An
Bord
Pleanála

Inspector's Report

ABP-308628-20

Development	110kV gas insulated switchgear substation compound, associated dropdown transmission lines, and associated development at Drogheda IDA Business and Technology Park, Donore Road, Drogheda, Co. Meath
Location	Drogheda IDA Business and Technology Park, Donore Road, Drogheda, Co. Meath
Planning Authority	Meath County Council
Applicant(s)	CAP Developments LLC
Type of Application	Application under the provisions of Section 182A of the Planning and Development Act 2000, as amended
Prescribed Bodies	TII & IAA
Observers	None
Date of Site Inspection	26 February 2021
Inspector	Una Crosse

02 Tower 01 - South Elevation
scale 1:200

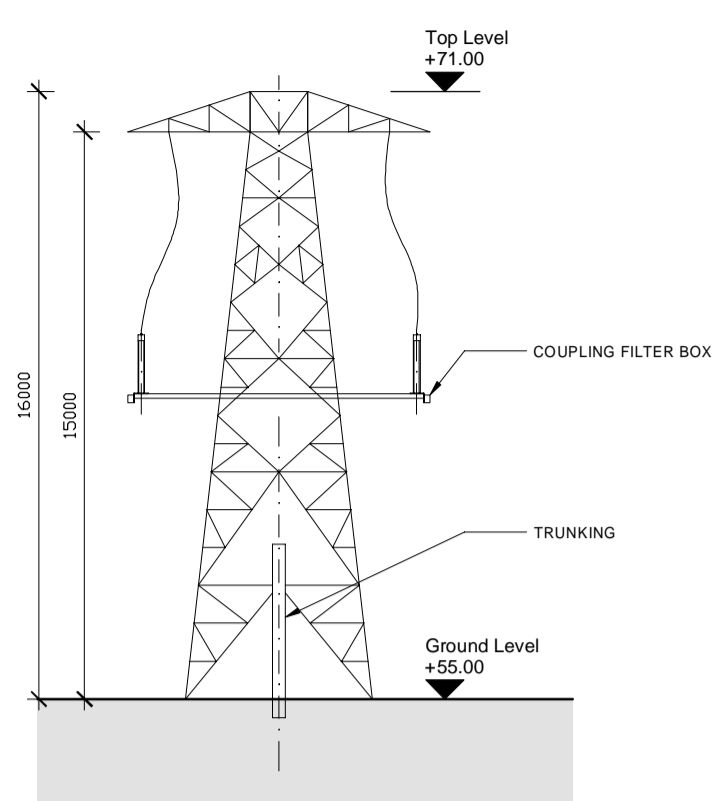
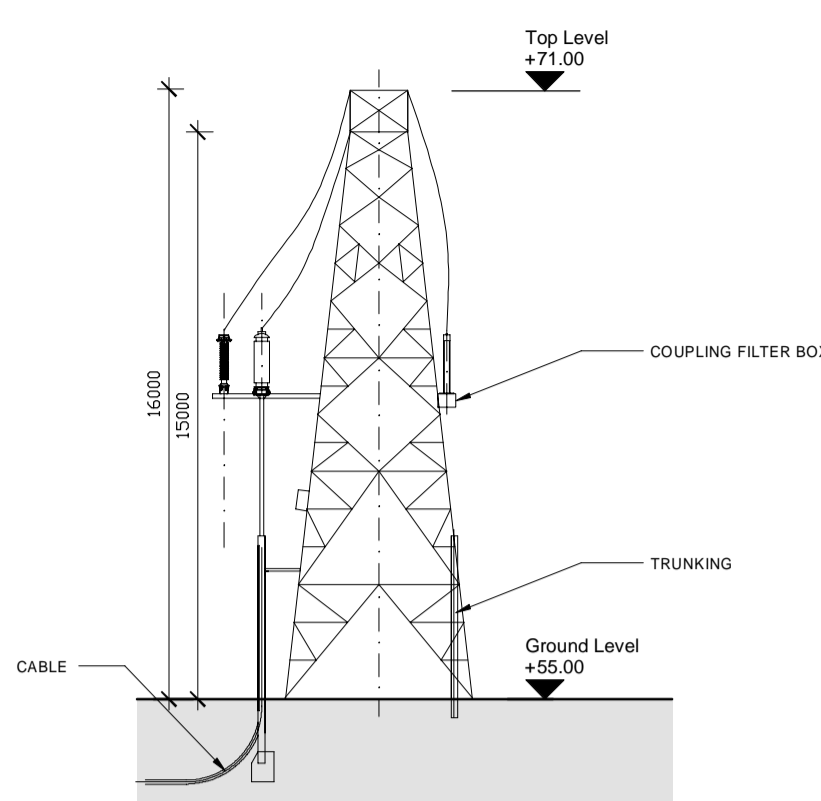
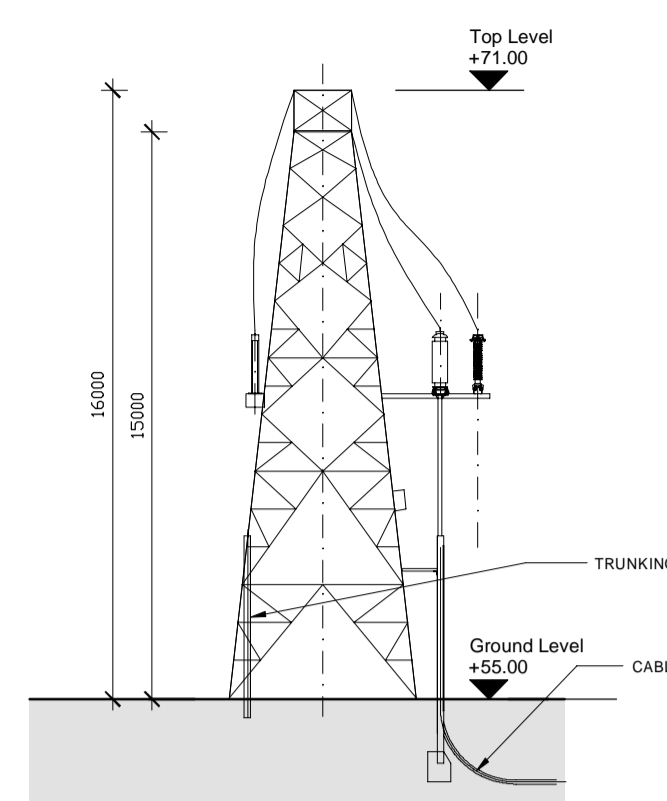
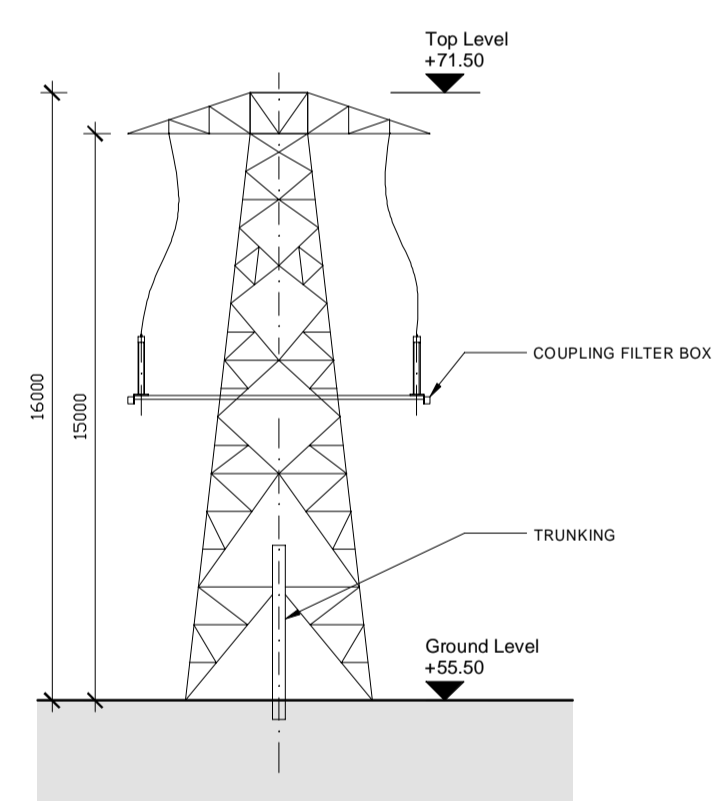
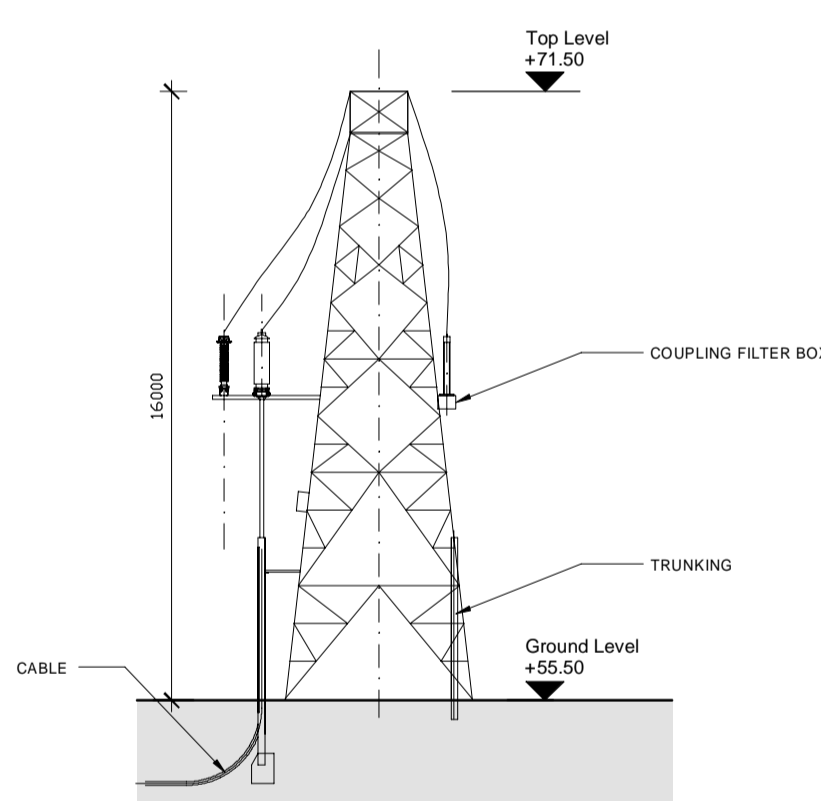
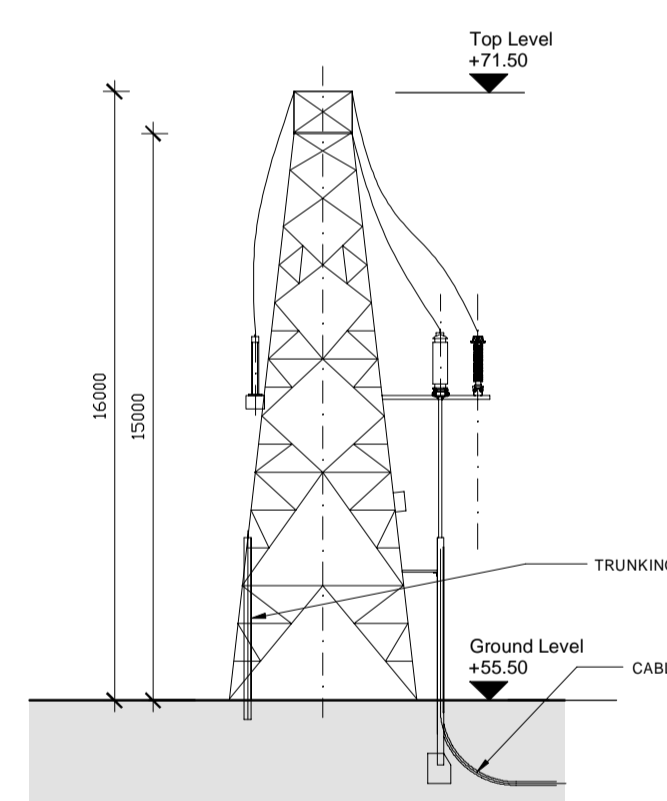
- As per previous report on data centre development, support structure and associated masts (tower 1 7 2) are too high and should be reduced in size.
- Business park has capacity to take two/three storey height building and what is being proposed is equivalent of 8 storeys.
